22. **Project # 1003913**
05DRB-00167 Minor-Prelim&Final
Plat Approval

**February 4, 2005
DRB Comments**

PROJECT # 1003913

RE: Tracts C-1 & C-2, Land of Tijeras Place Improvement/minor

PLAT OF  
**LOT C-1-A**  
**LAND OF TIJERAS PLACE IMPROVEMENT CO., INC.**

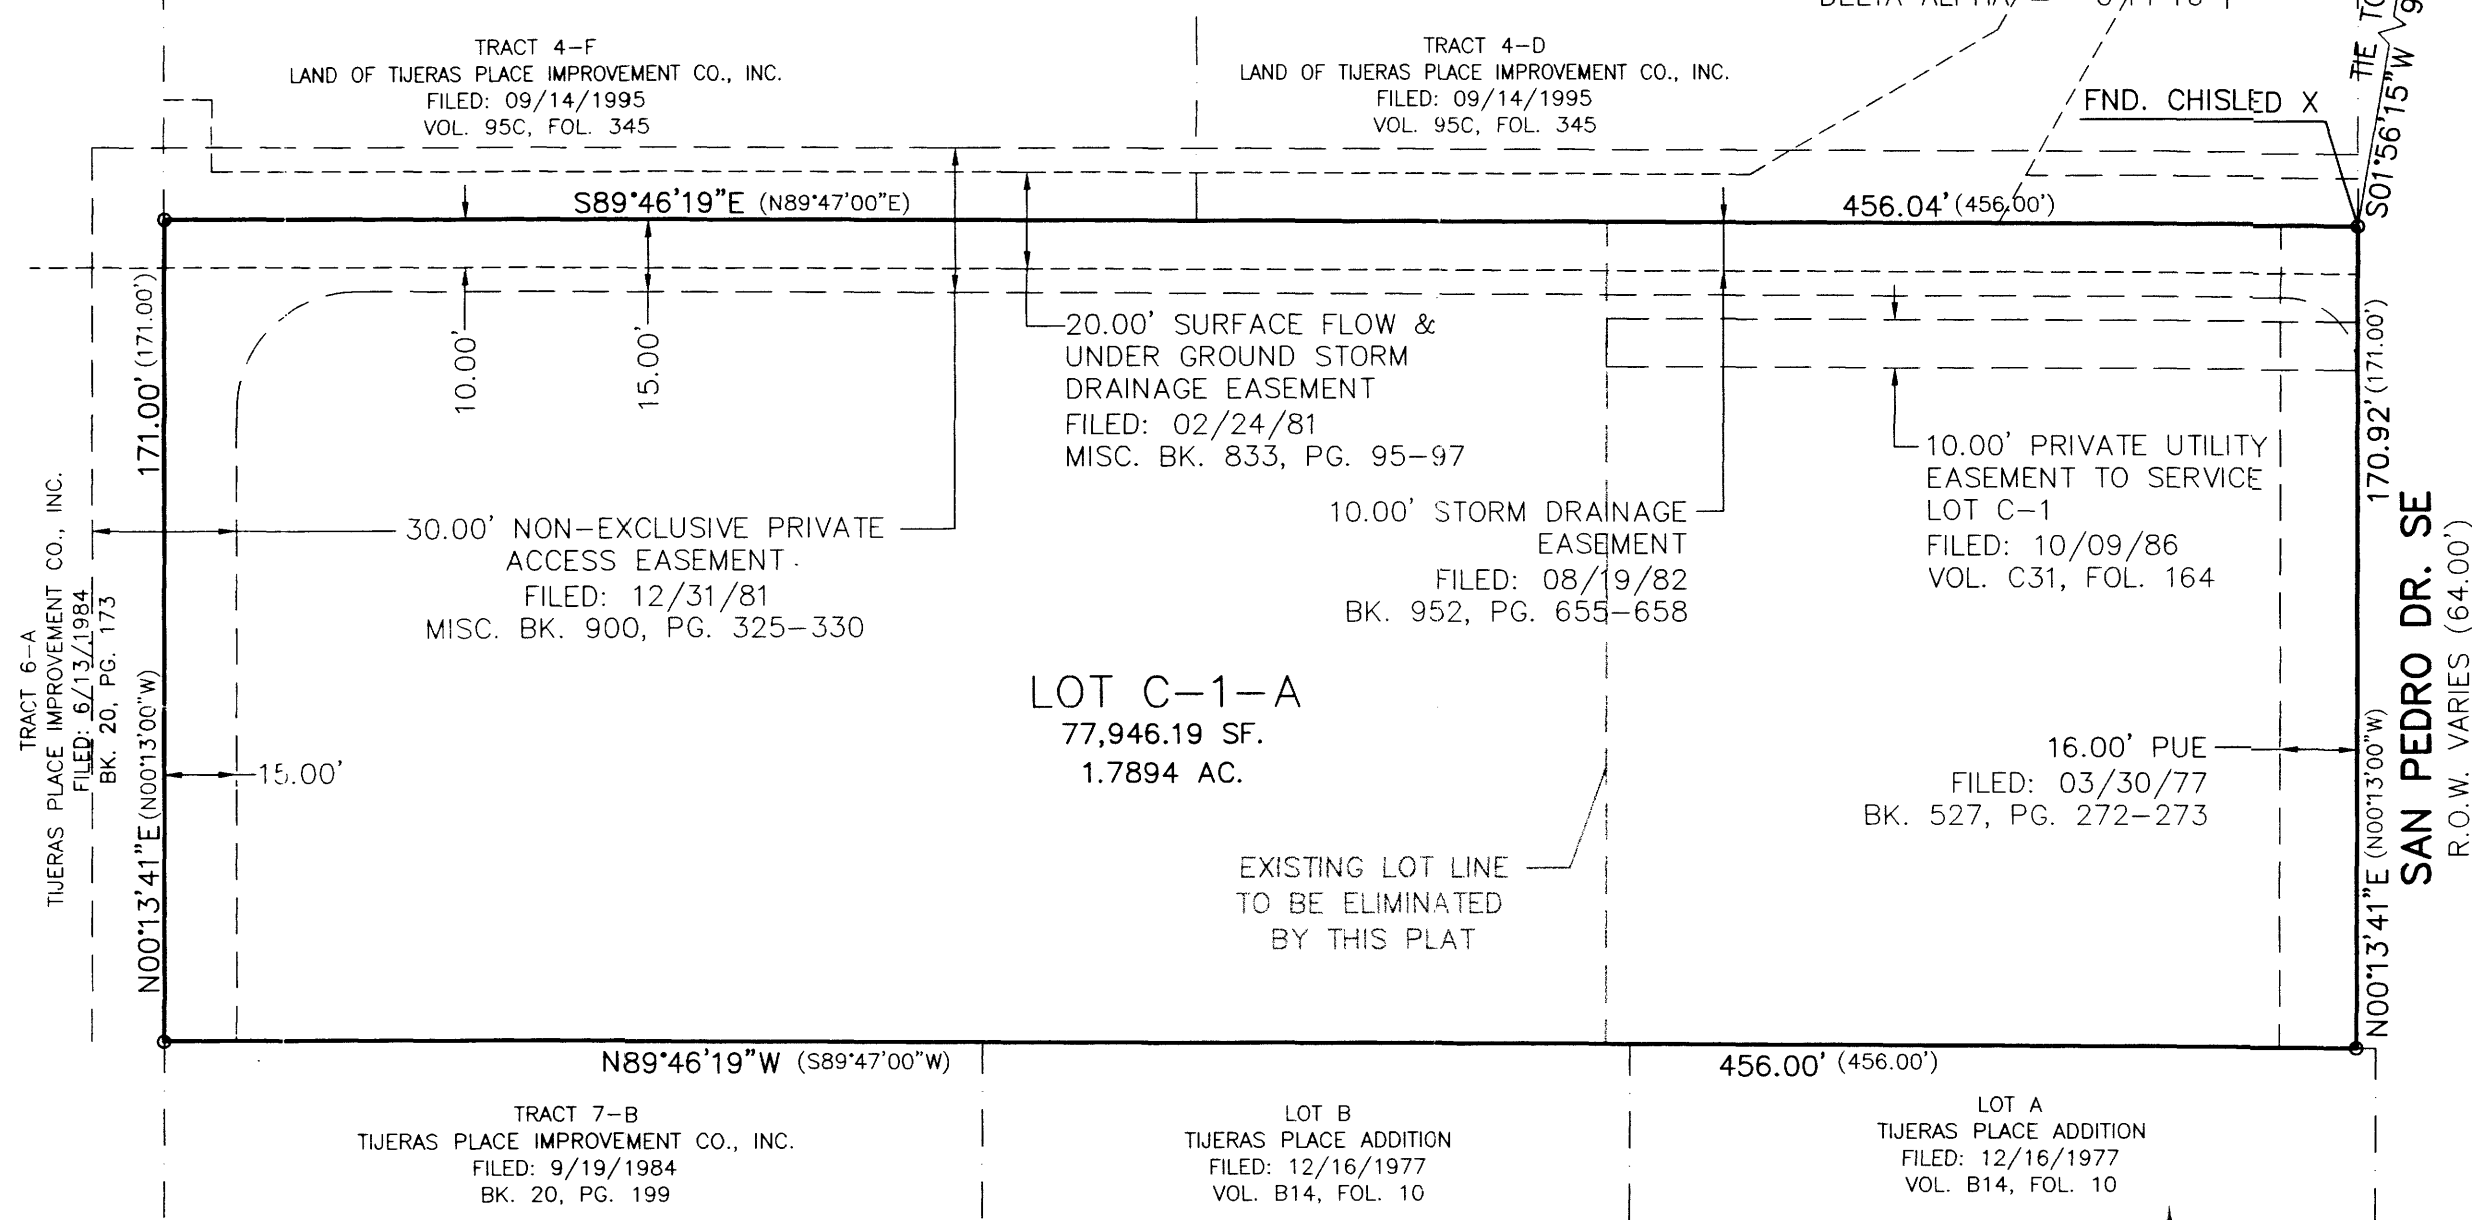
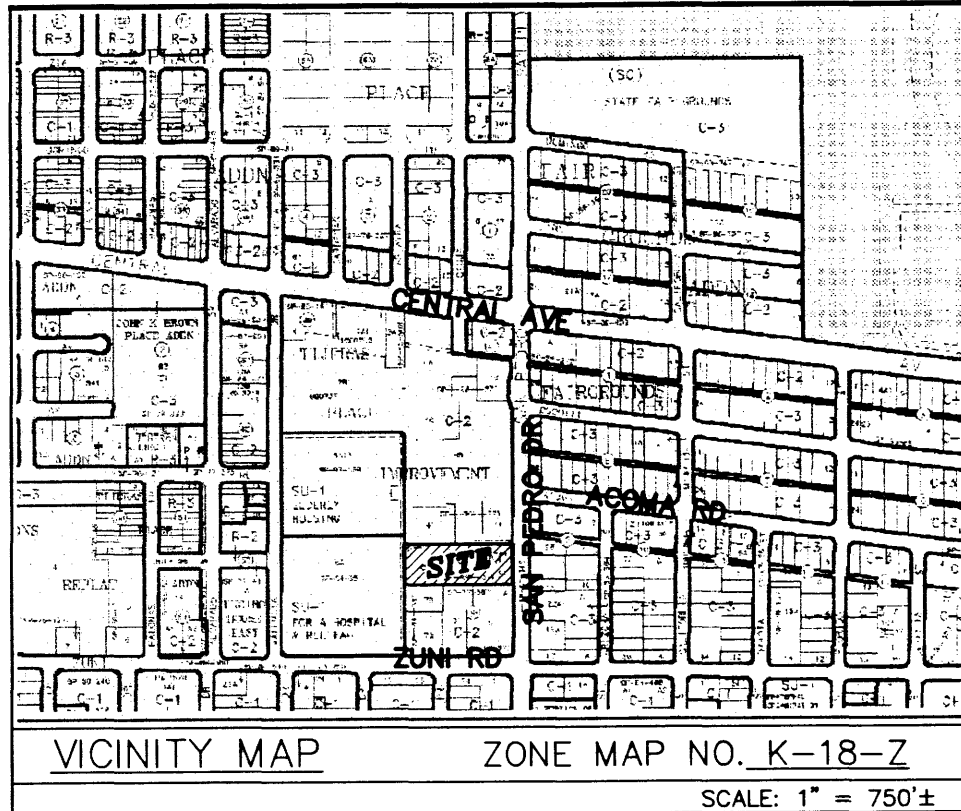
<u>No.</u>	<u>Comment</u>
1)	San Pedro is collector and requires 68' of right-of-way.
2)	This stretch is also identified as a bike lane corridor, 6' additional may be required. Suggest meeting with DMD - Transportation to verify requirements.
3)	Where is curb face in relation to existing property line? Sidewalk location and width?
